Our Ref: R/249/17/PDH
Your Ref:

Town and Country Planning Act 1990 (As amended)
Town and Country Planning (General Permitted development) Order 2015 Schedule 2 Part 1
Class A
Application for Prior Notification for a householder extension

Development Notification under extended permitted development rights for replacement conservatory extending m from the original rear wall of the dwelling house. 3.3m high with an eaves height of 2.7m

Location 14 Windmill Drive Rustington

PROPOSED FLOOR PLANS 1:50

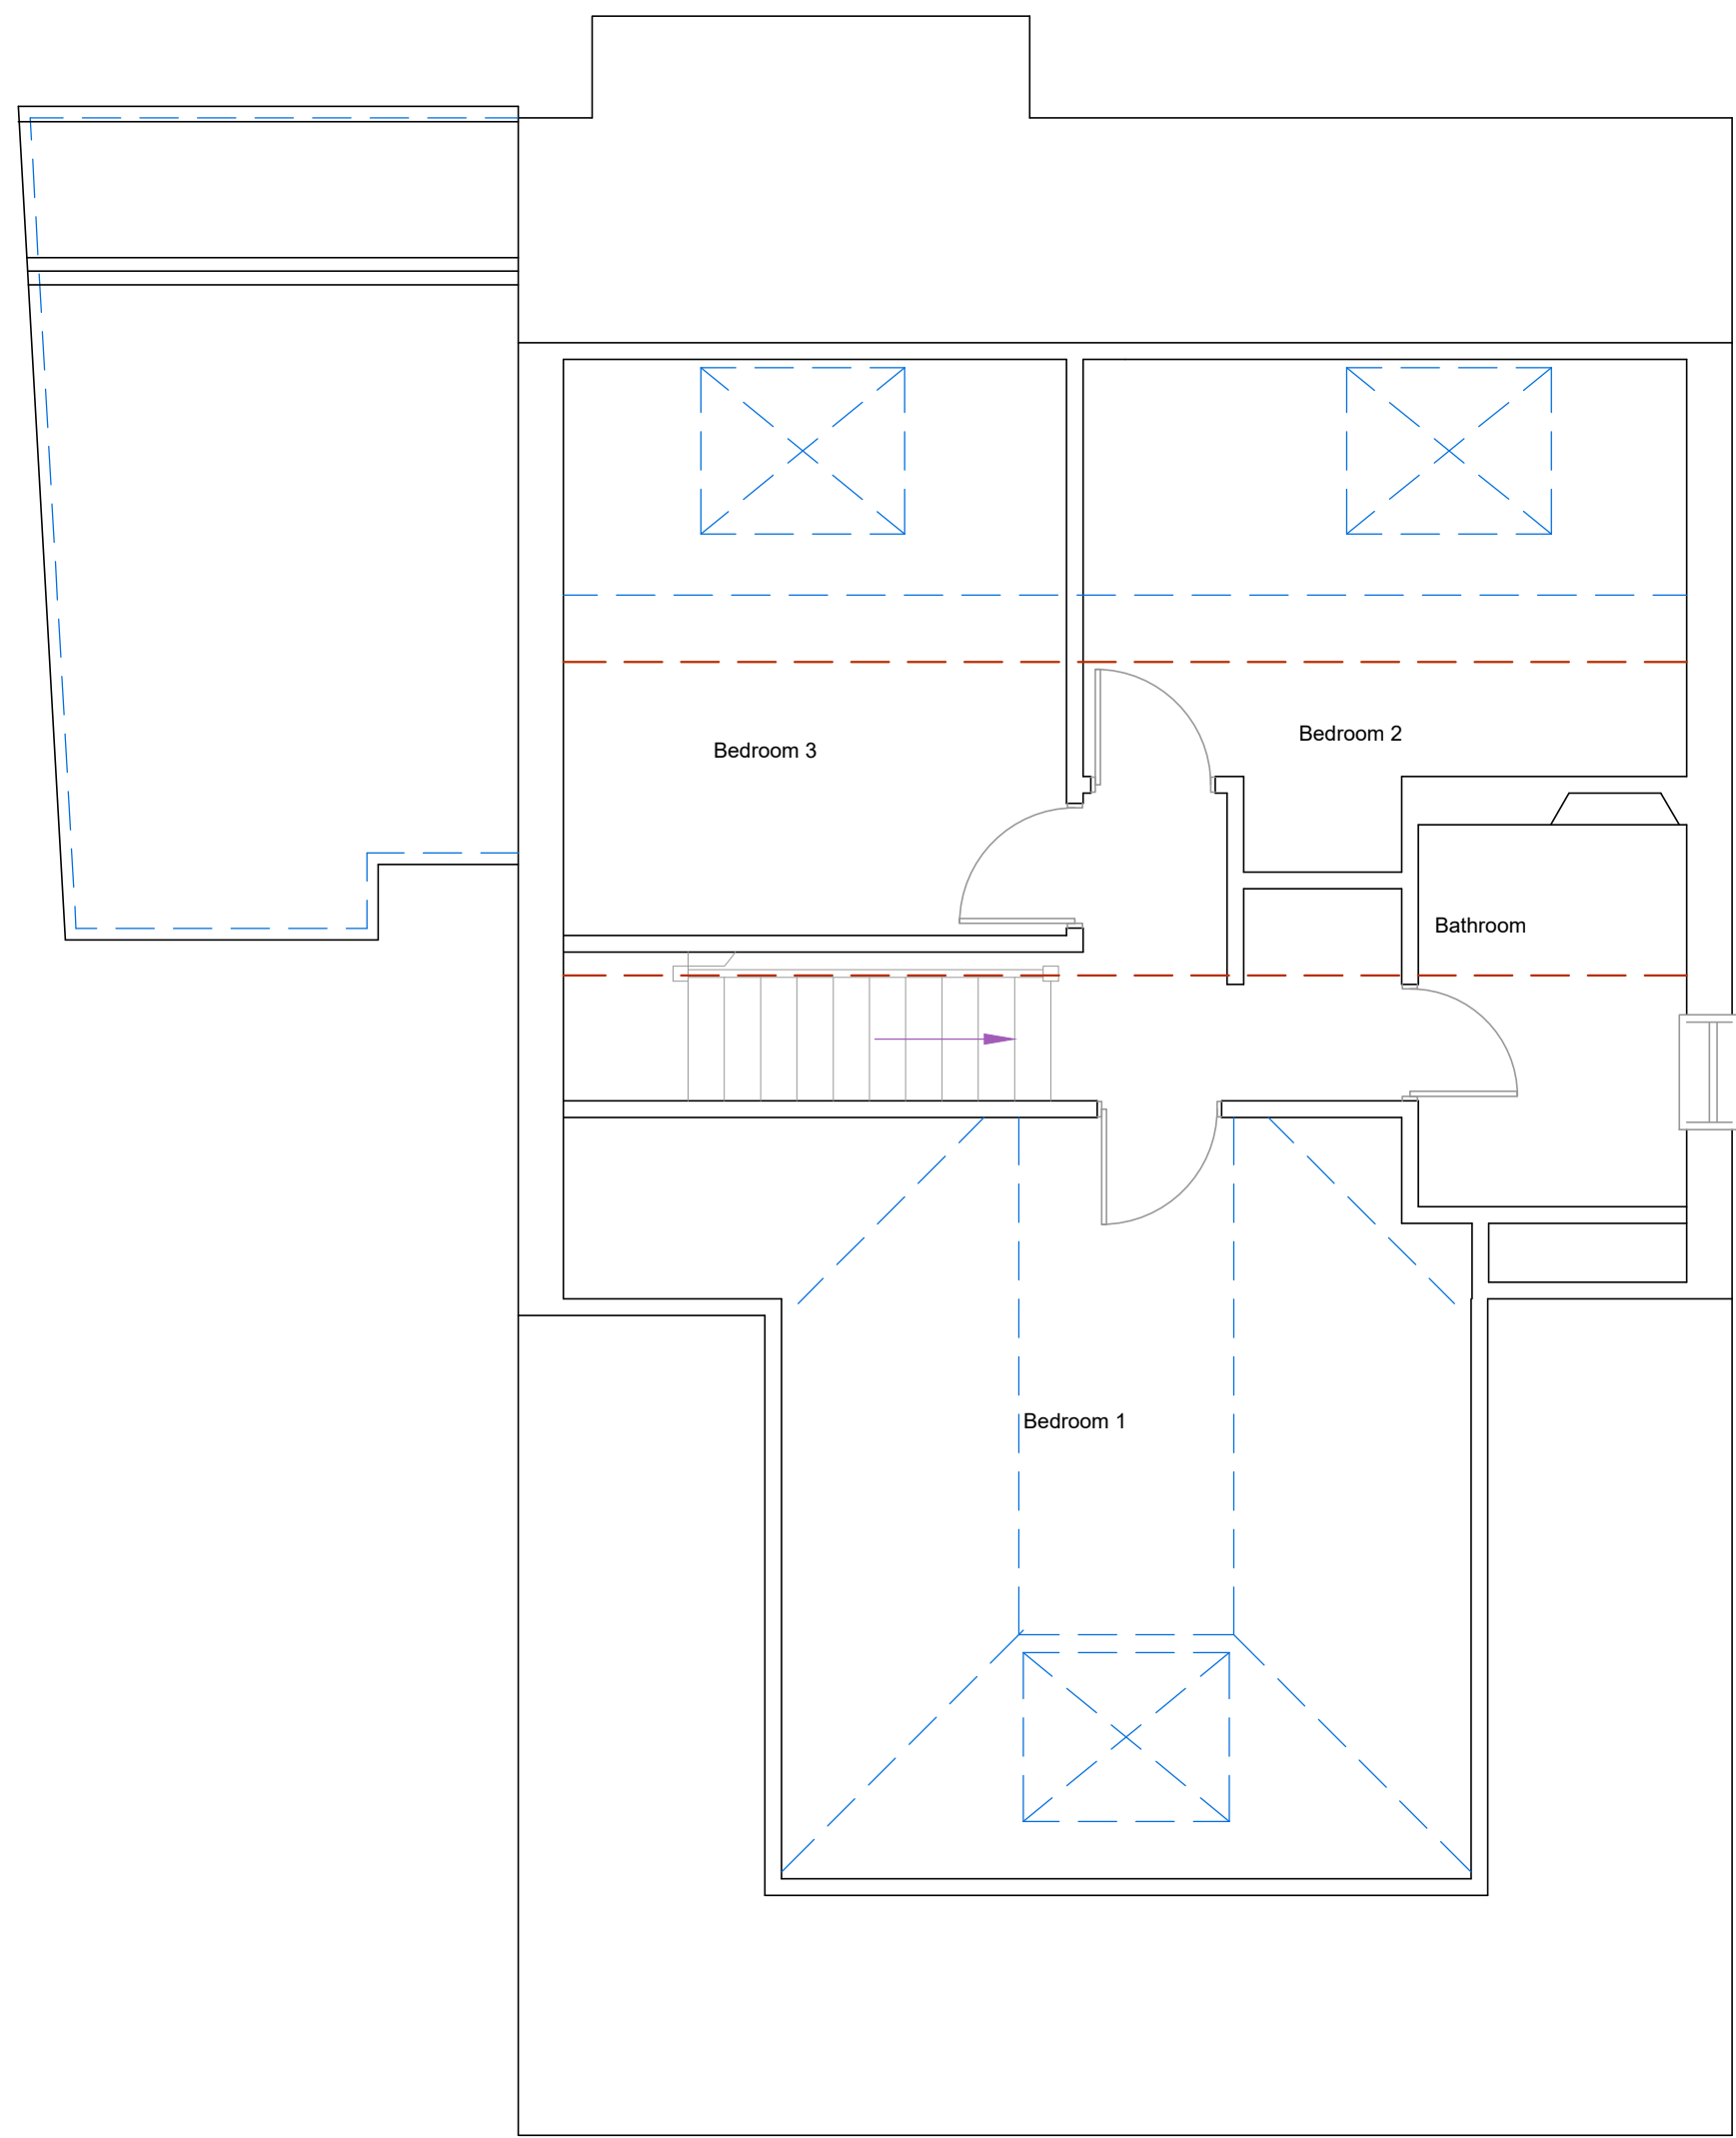
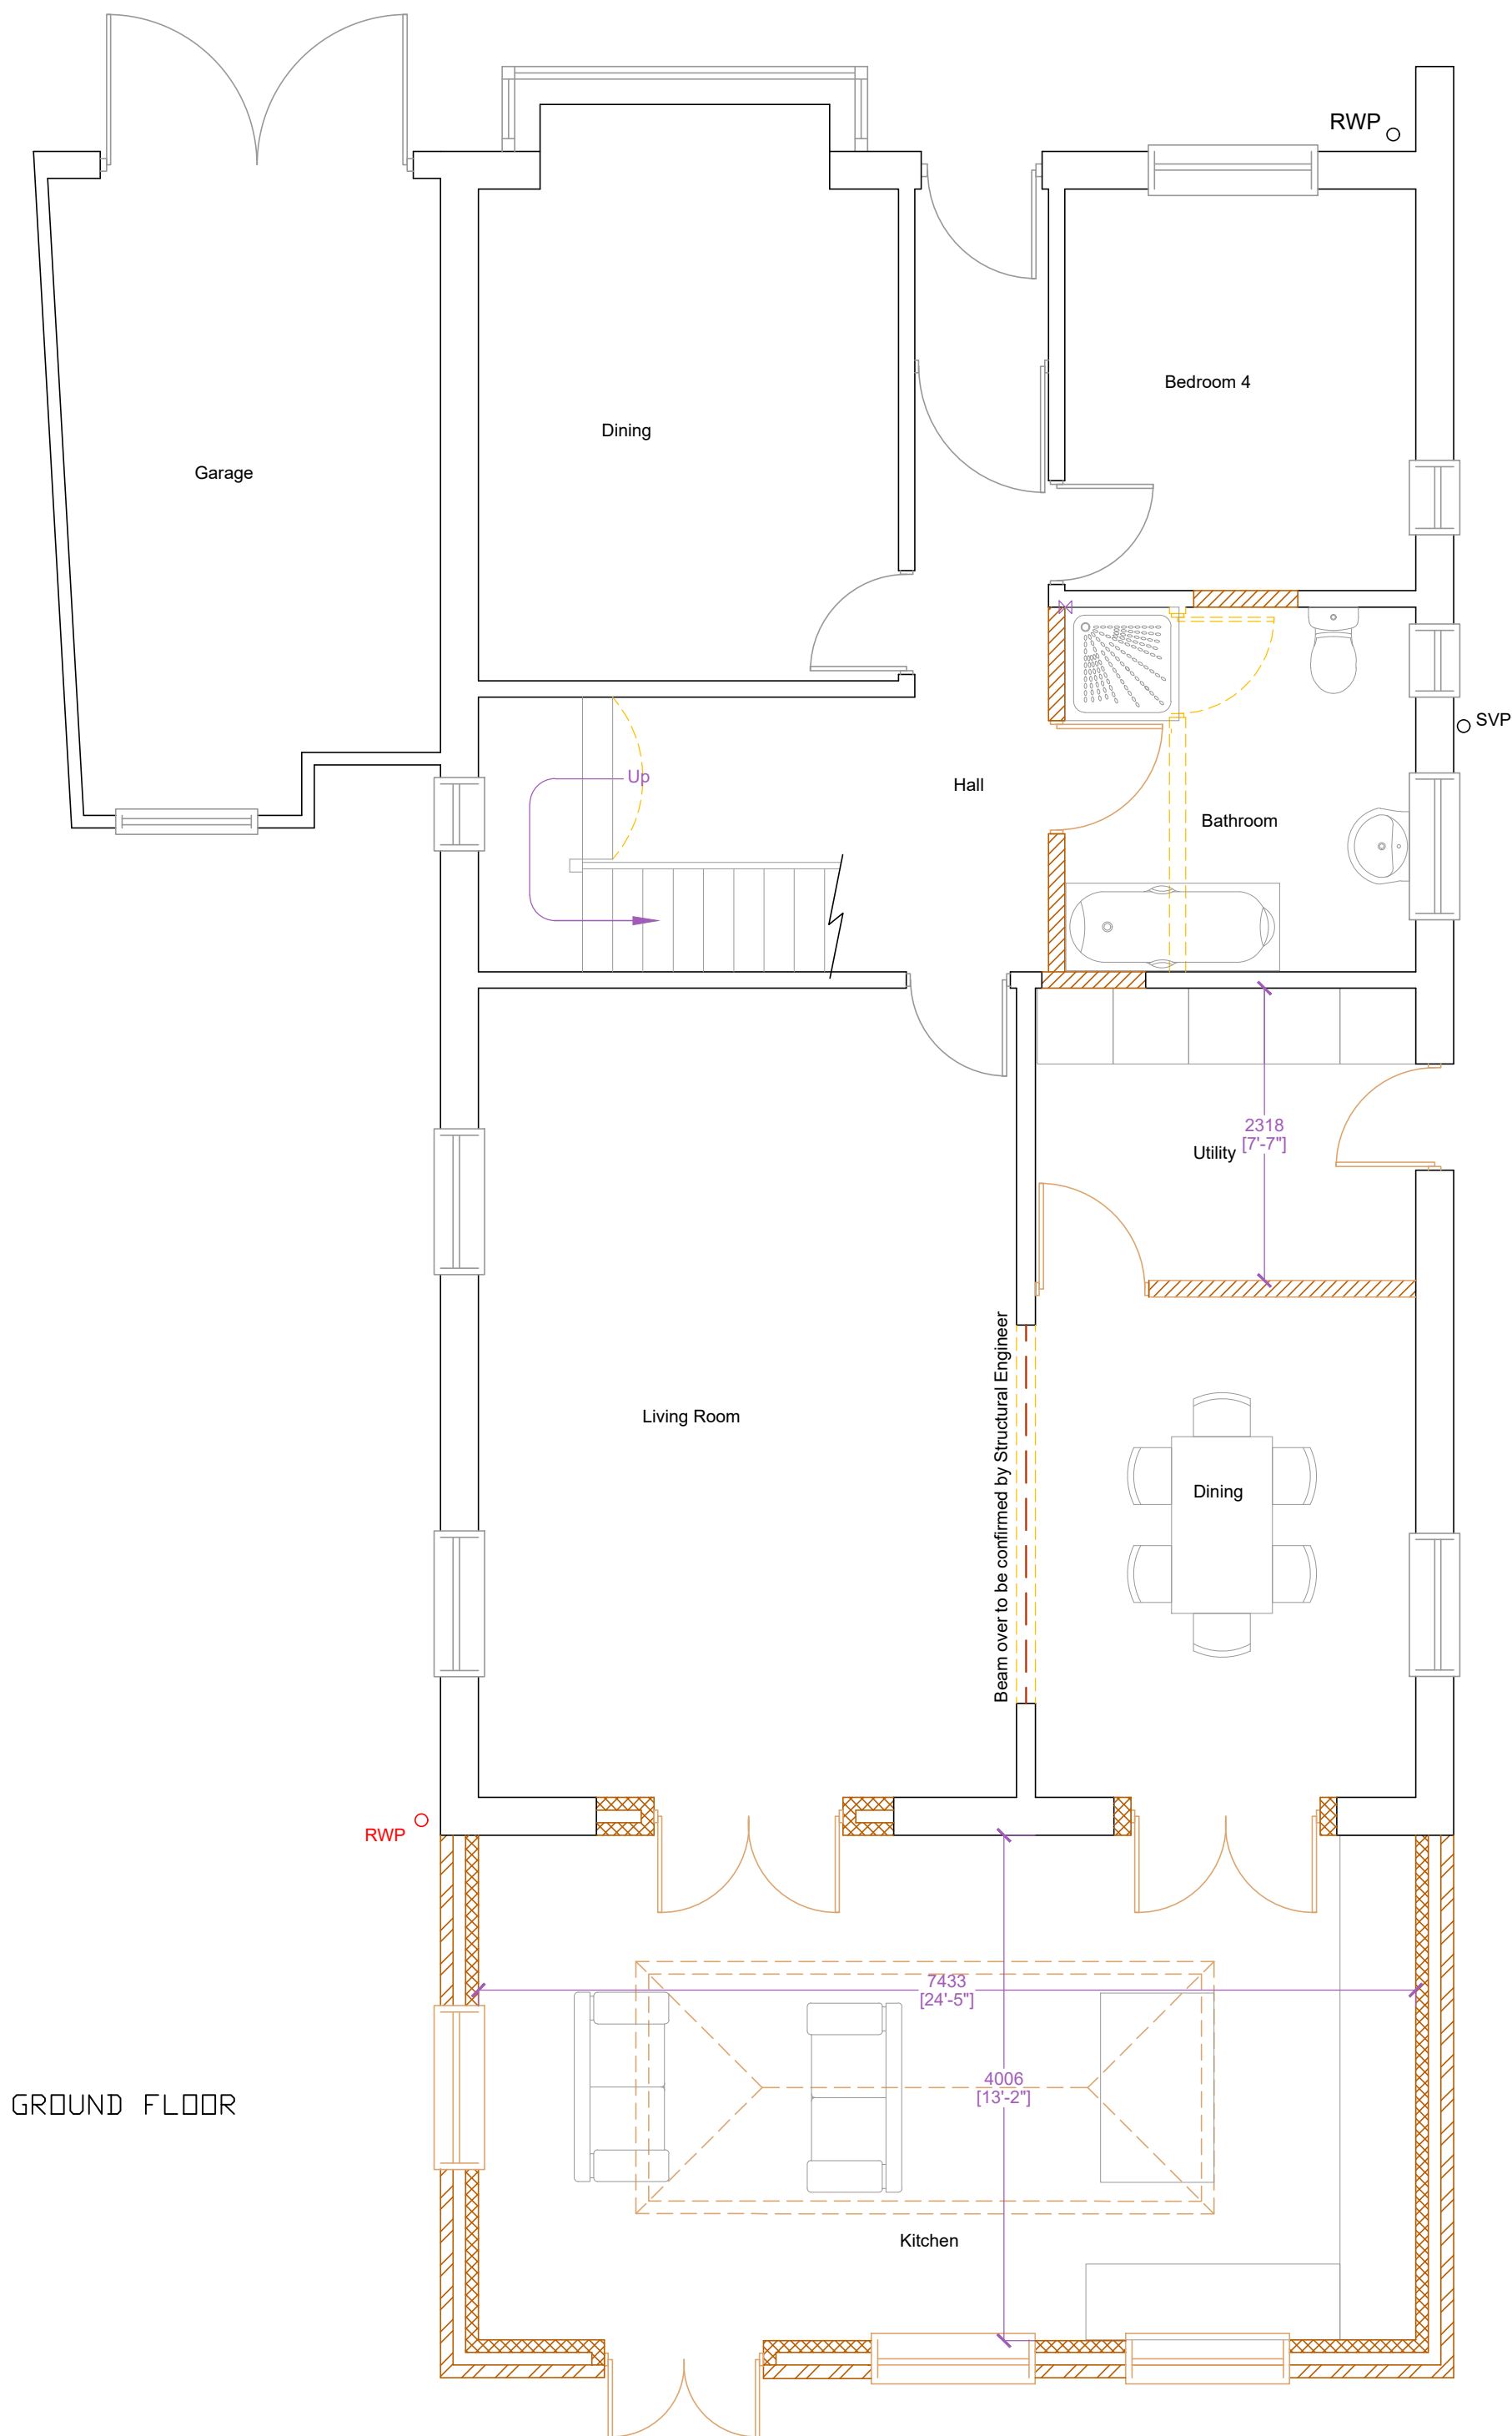
I'm not sure the measurement of the extension is correct. I believe the extension measures 4.2m and not 7.7m as stipulated on the form. Please confirm the measurement (length) of the proposal.
